February 11, 2009

Thank you for the opportunity to comment on the D Knudson Short Plat, SP-08-00049. Pursuant to the Memorandum of Agreement between Kittitas County and the Washington State Department of Ecology all residential well connections serving the proposed lots shall be required to have meters installed. Metering results shall be recorded in a manner consistent with Kittitas County and Washington State Department of Ecology requirements.

SUBJECT: D Knudson Short Plat SP-08-00049

D KNUDSON SHORT PLAT
KITTITAS COUNTY SHORT PLAT NO. 08-XX
PORTION OF SECTION 31, TOWNSHIP 18N., RANGE 20E., W.M.
KITTITAS COUNTY, WASHINGTON

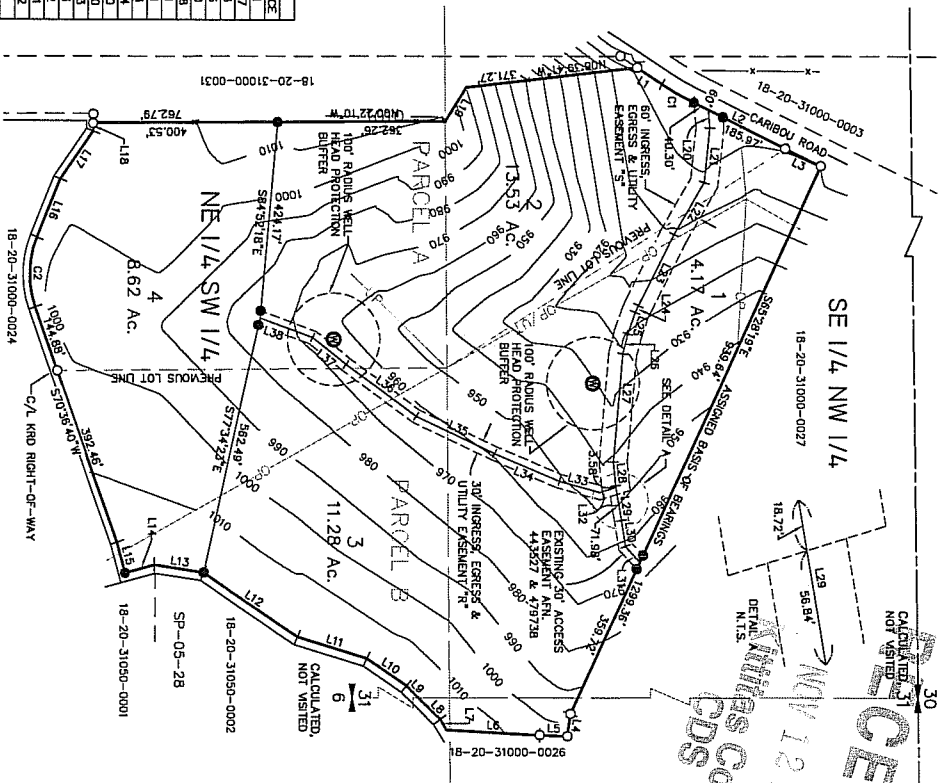
At this time it appears that the southernmost well on lot #2 may not meet a required setback. The short plat has proposed individual wells for all lots; individual wells are required to have a 50-foot setback from neighboring property lines. It appears that this well does not meet the 50-foot setback from property lines between lot #2 and lot #3. It is recommended that either 1) the property line be moved to accommodate the required setback or 2) the well be shared between lots #2 and #3. The application also does not contain soil assessment information to determine if the land area is suitable for onsite

3. County Road Access: The access onto Caribou Road shall intersect at no greater than 10 degrees from perpendicular. Additional easement may be required for the turning radius.

4. Private Road Improvements: Access shall be constructed as a Low-Density Private Road. A cul-de-sac shall be constructed at the end of the 60' Easement 'S' or at the point where no more than two lots are served by the road. If more than two lots are served by the 30' Easement 'R' the easement shall be increased to 60' and the cul-de-sac constructed along the easement. See Kittitas County Road Standards, 9/6/05 edition.
